**Water Resources and Water Quality Report
For
Cloverleaf Subdivision
El Paso County, CO**

June, 2020

JR Project No. 25158.01

CLOVERLEAF WATER MAP

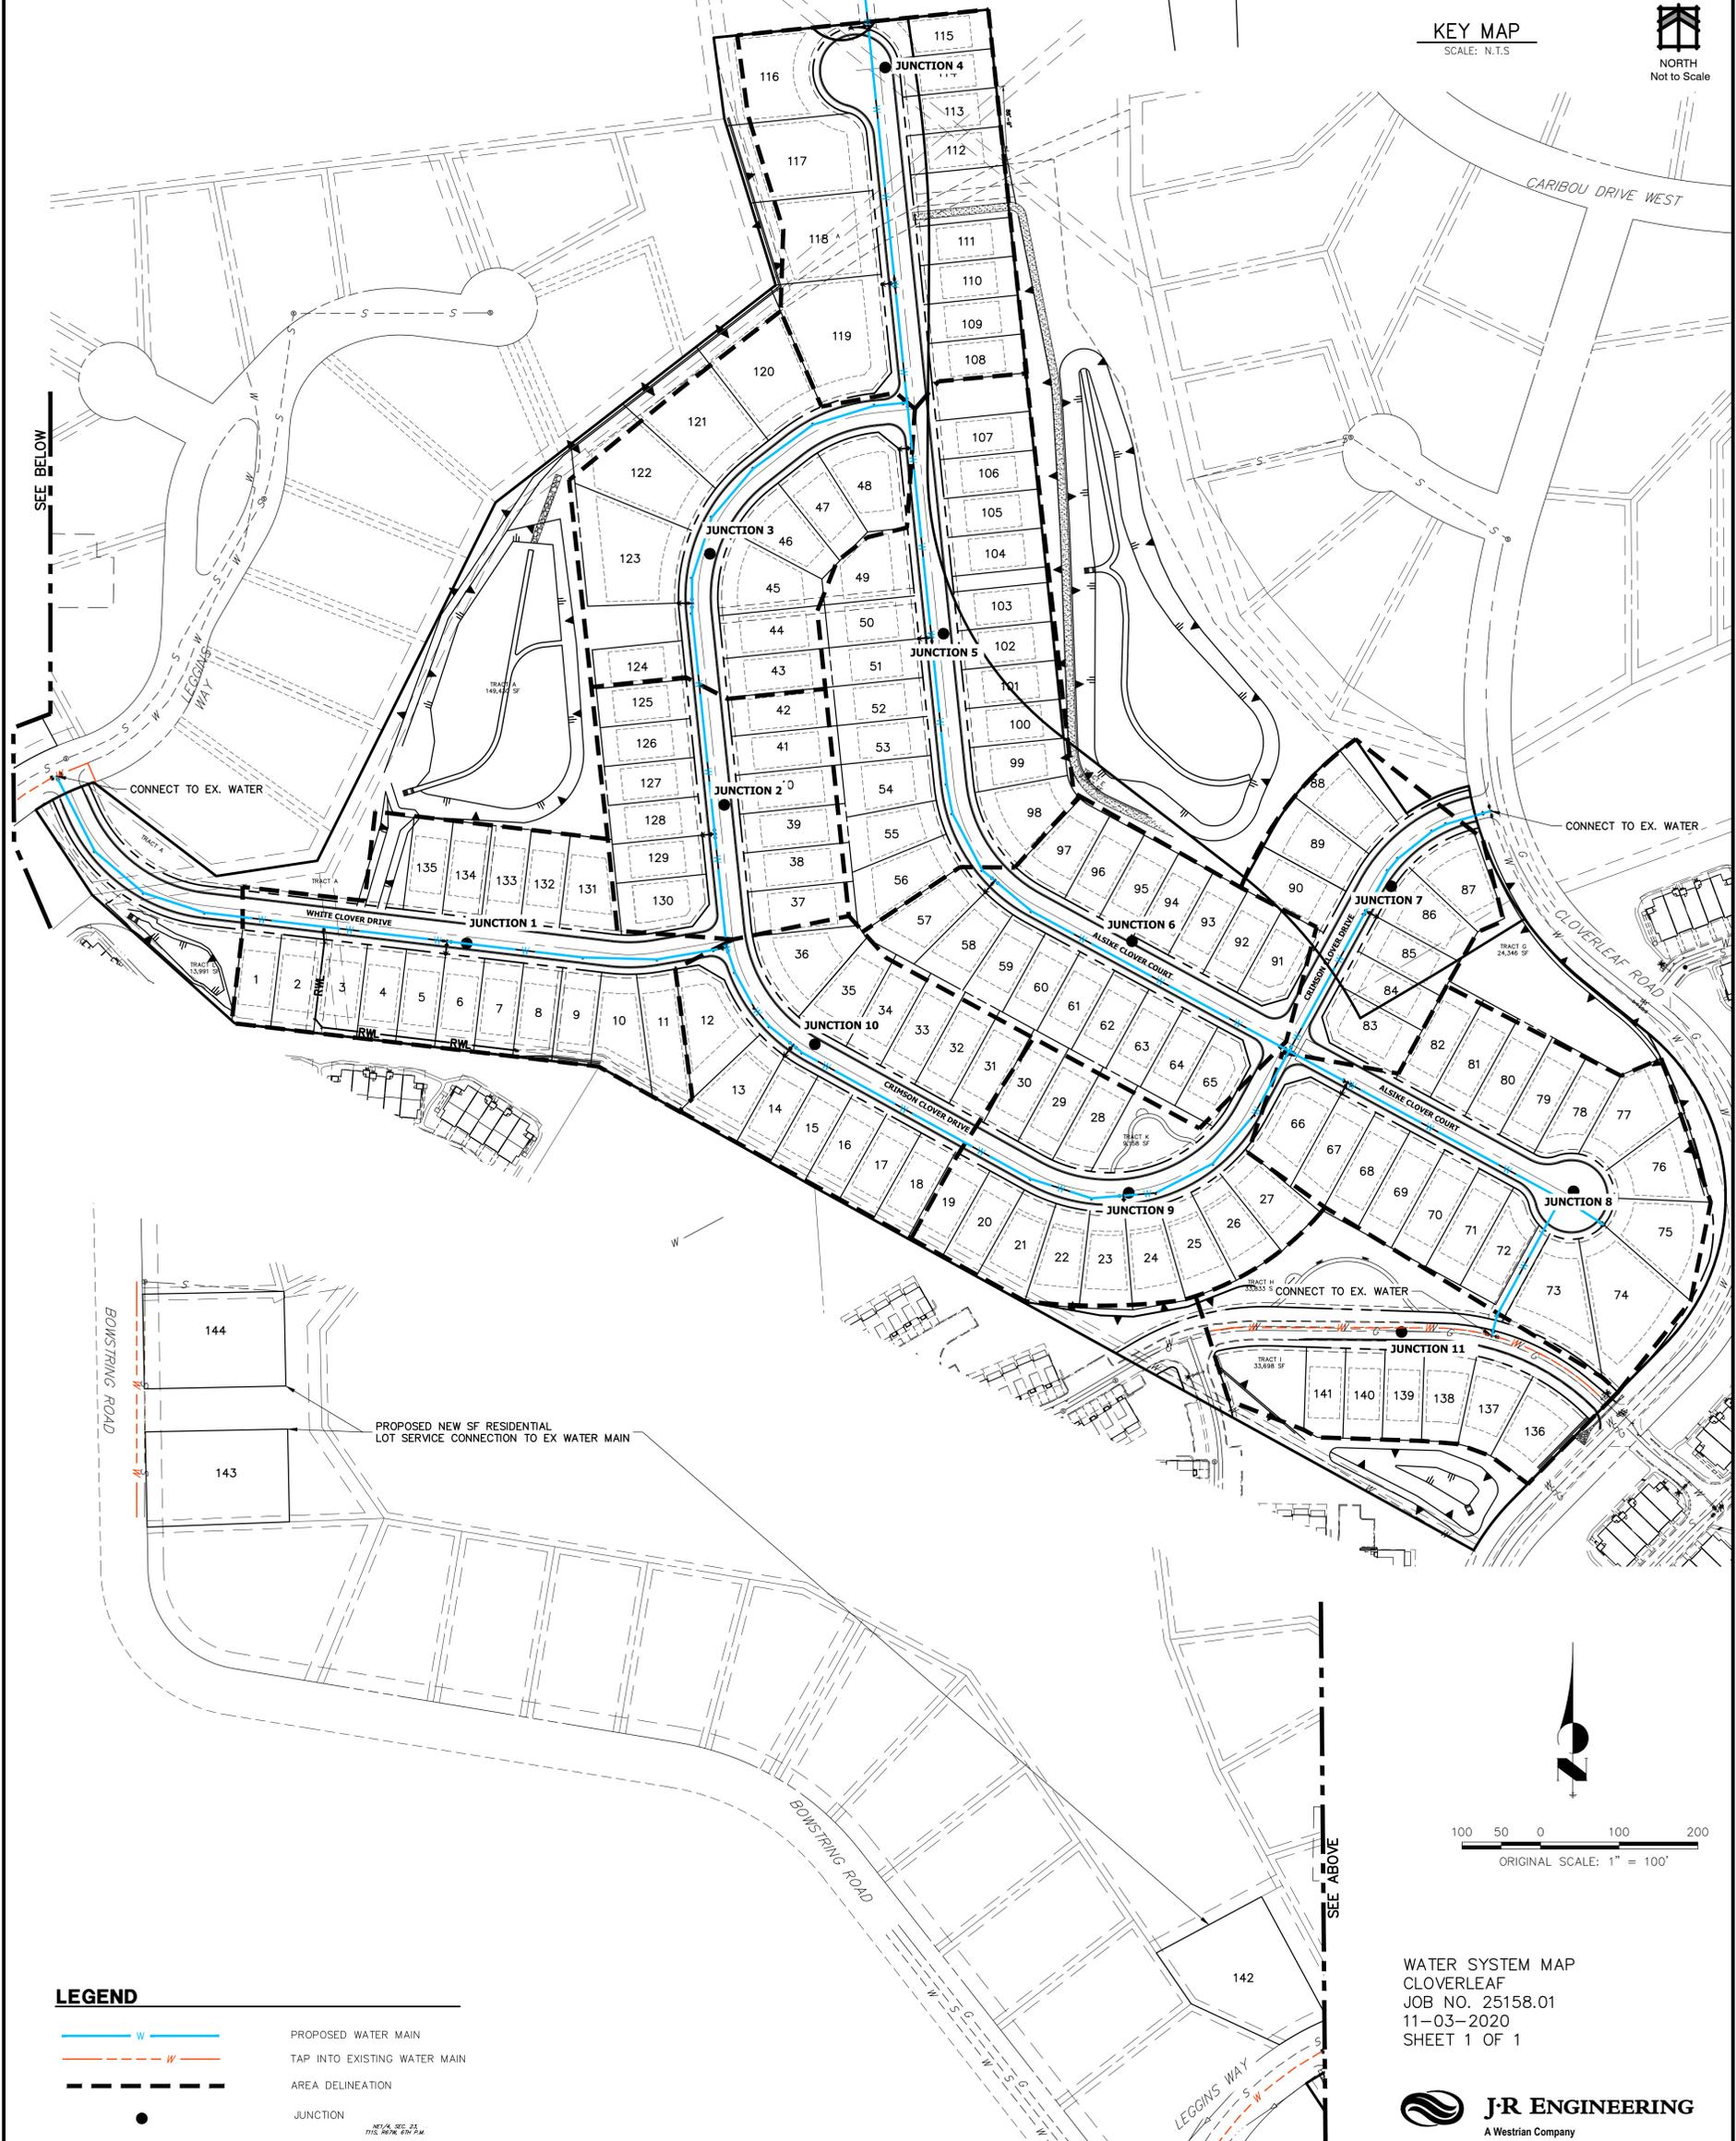
Should show all parcels that are included in the prelim plan.

JR Response: Addressed.
